REPORT UPDATE

Application No: A/154/14/OUT

Recommendation Report for Outline Consent

PROPOSAL: Outline Application for the erection of 18 No. dwellings

DEVELOPABLE SITE AREA - 0.72 Hectares

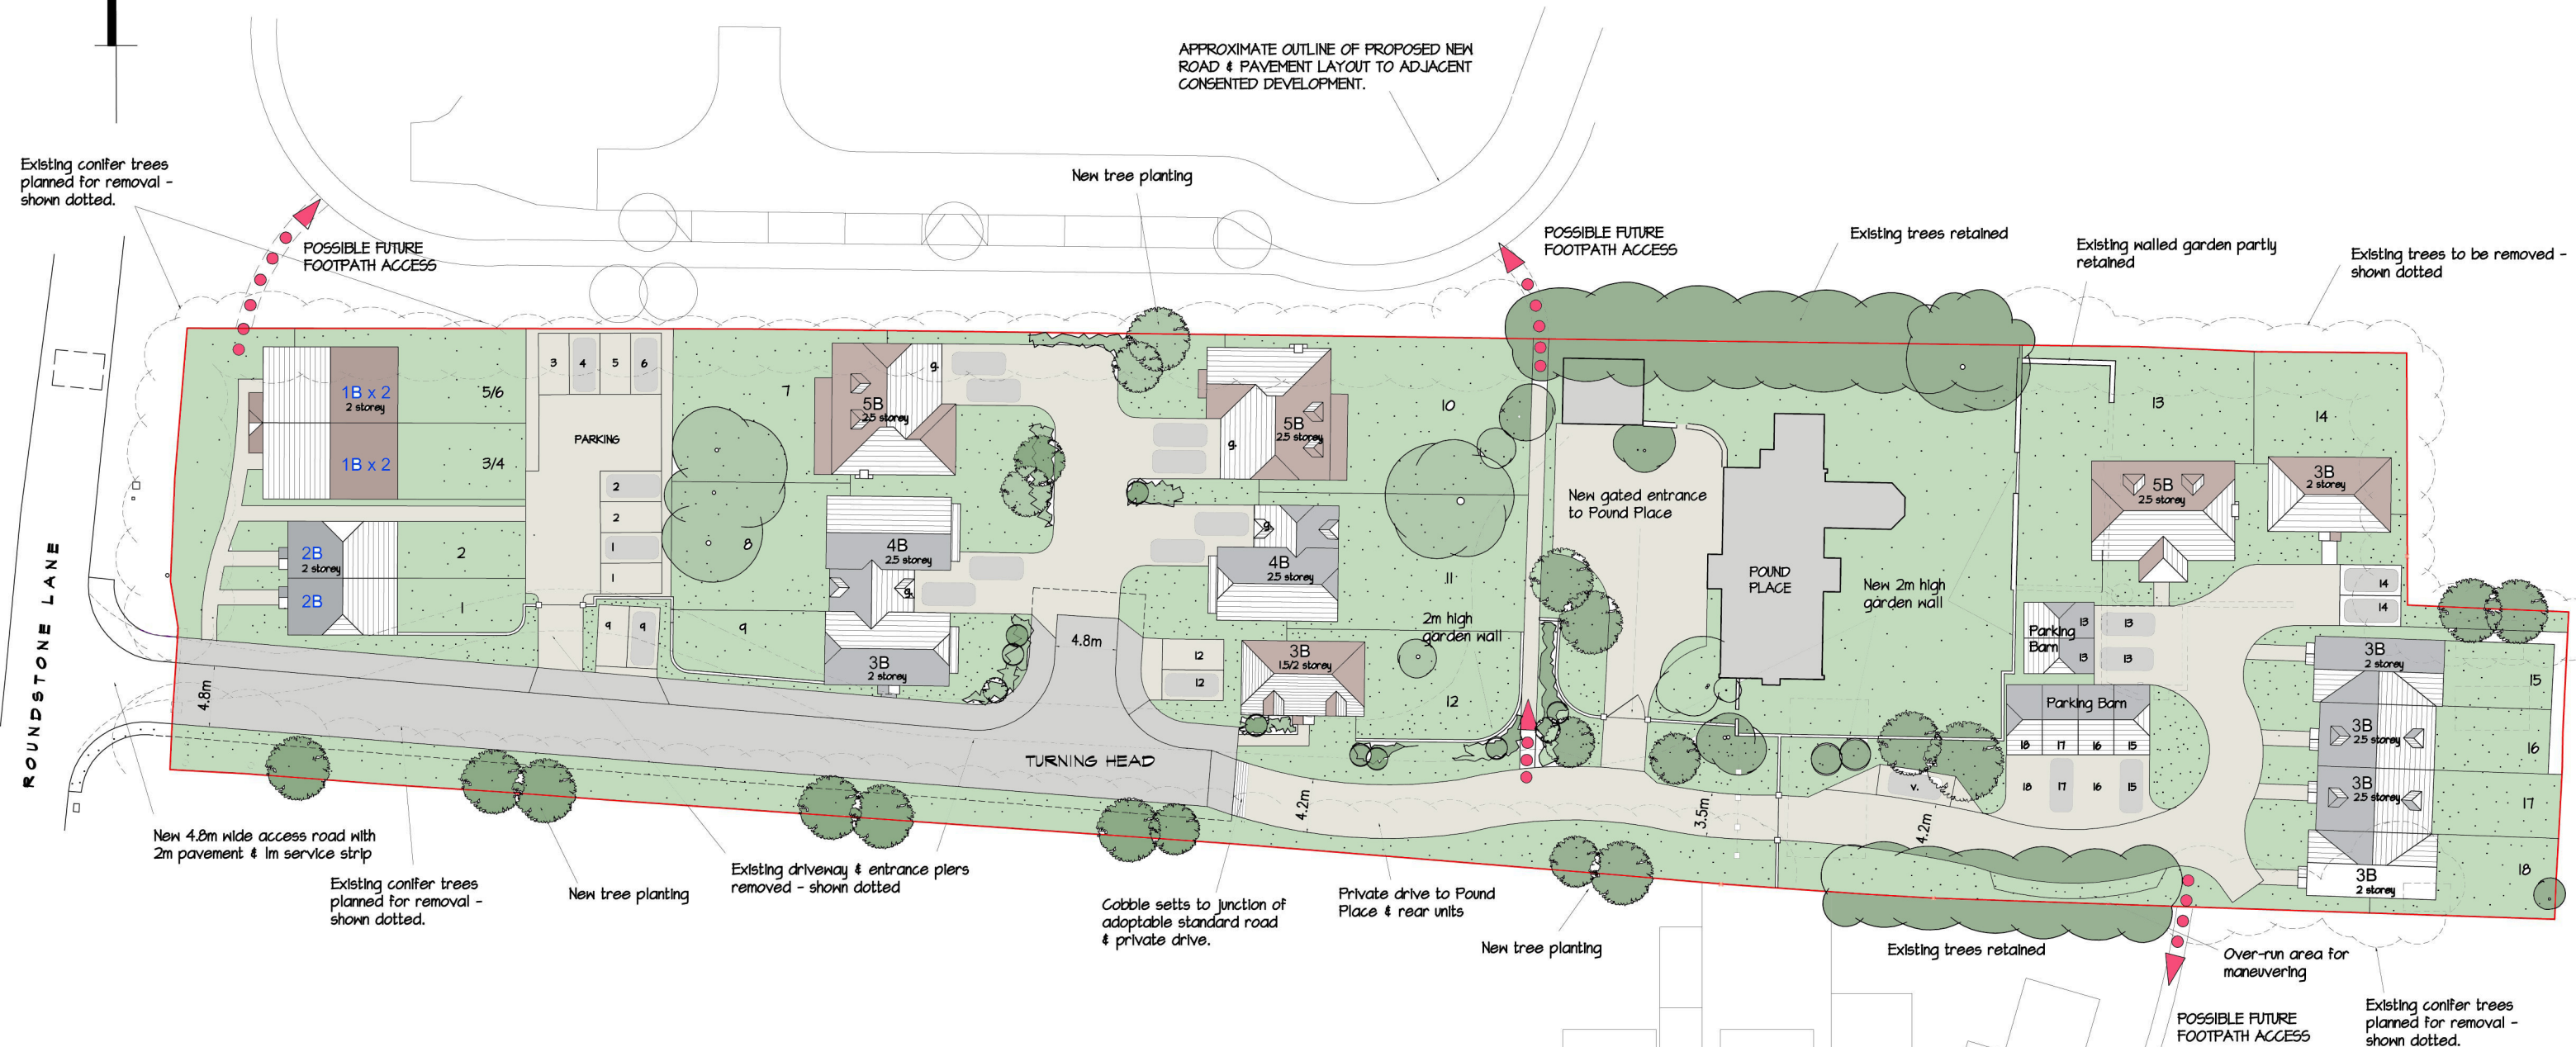
Whilst I note that permission is sought for access only I can offer the following comment on the internal layout. Tracking should be undertaken to demonstrate that the internal roads can accommodate the movement and turning of a refuse vehicle.

The alignment of the internal road is straight and its length could encourage vehicles to travel at inappropriate speeds; I would suggest that either the alignment is altered or that features are introduced to discourage higher vehicle speeds.

The carriageway width narrows to 3.5m at the eastern part of the development. I would recommend that a minimum road width of 4.1m is maintained at the shared use sections.

The application under consideration is in outline form with all detailed design issues reserved. As submitted, the indicative layout plan is not acceptable as it is deficient in the provision of open space and officers are not yet convinced that 18 dwellings could be accommodated on the site. The applicants are proposing to submit a revised layout which indicates that the scheme which complies with the masterplan. Should one not be submitted, a recommendation of refusal will be made.

SCHEDULE OF UNITS - 18 Total New Dwellings (Existing House to remain)

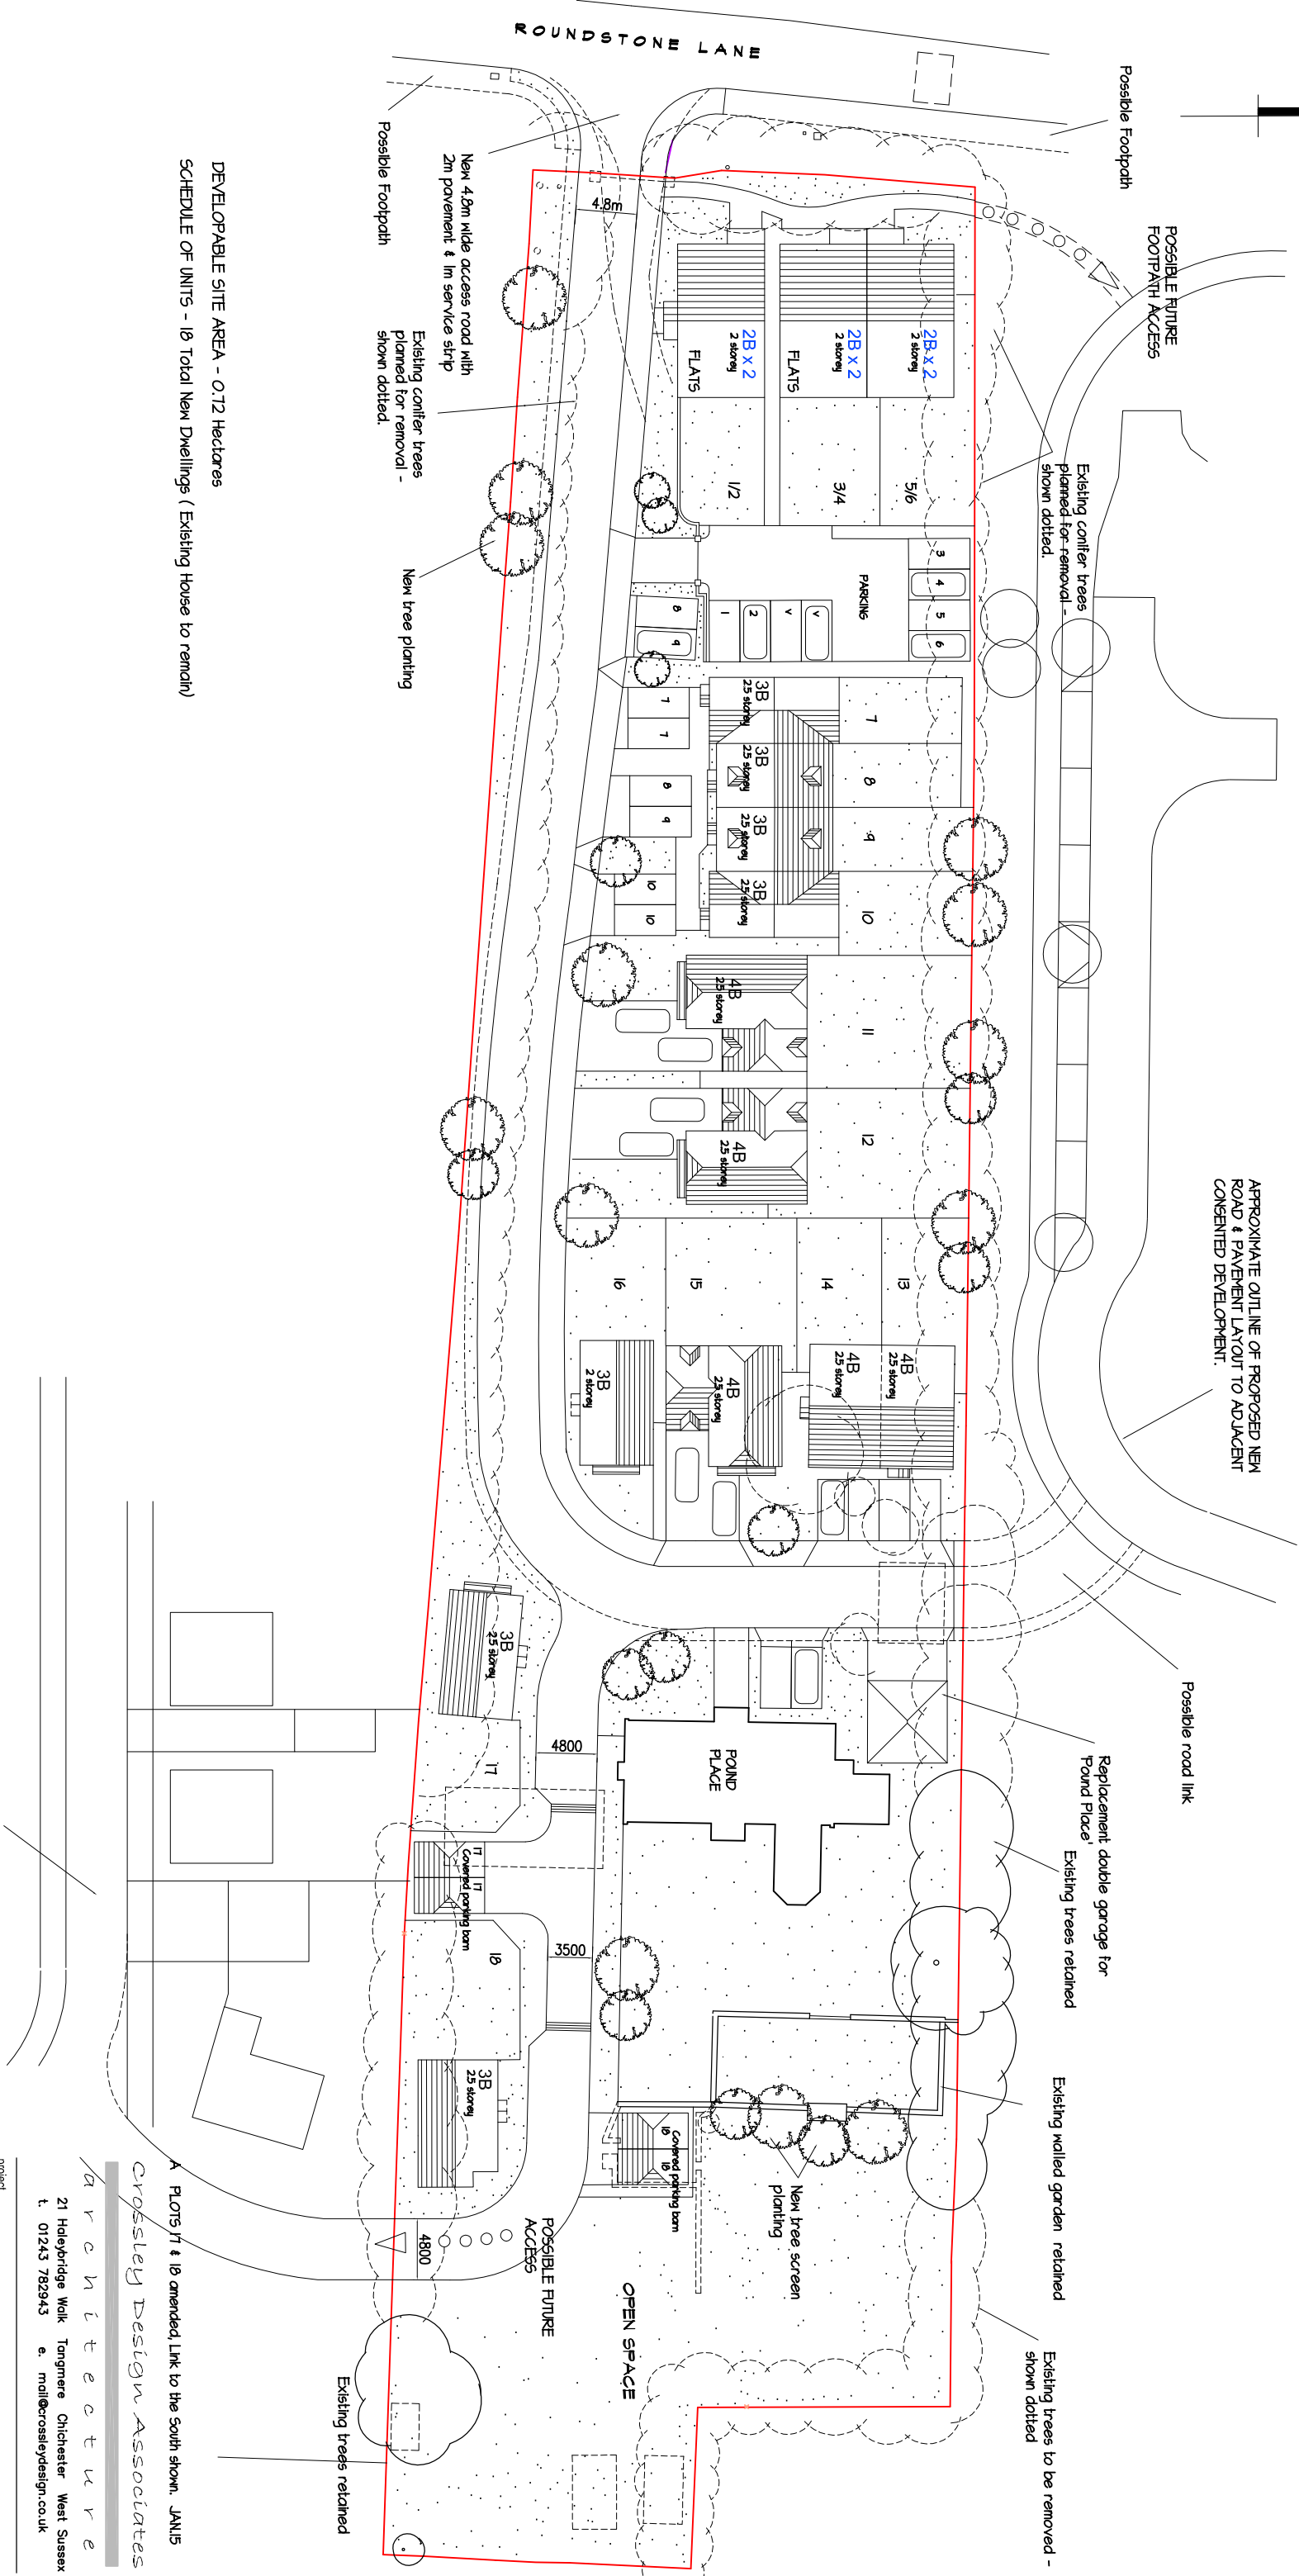
A revised layout has been submitted. This is indicative at this time but it now shows that adequate open space can be provided. Whilst this plan is indicative (and is therefore acceptable for the purposes of an outline planning permission), there are a number of significant issues that will need to be addressed at reserved matters stage. The indicative scheme fails to provide a 'frontage' to the open space and it shows dwellings that back onto the open space with rear garden boundaries. This would not be acceptable at a reserved matters stage and would not accord with the approved masterplan.

At this time, it appears unlikely that the existing dwelling could be retained in any site redevelopment that would result in an acceptable reserved matters layout.

INFORMATIVE: The applicant is advised that, whilst the Council is satisfied that a layout accommodating 18 dwellings can be achieved on the site, there are significant objections to the indicative layout submitted with the application. Any reserved matters submission will need to demonstrate that it can link the approved schemes to the north and south together with pedestrian and vehicle movement and will need to incorporate good design principles to provide an open space that is overlooked by development (as the schemes to the north and south do). At this time, it appears very unlikely that any scheme that seeks to retain the existing dwelling on the site could provide a satisfactory layout that satisfies these requirements.
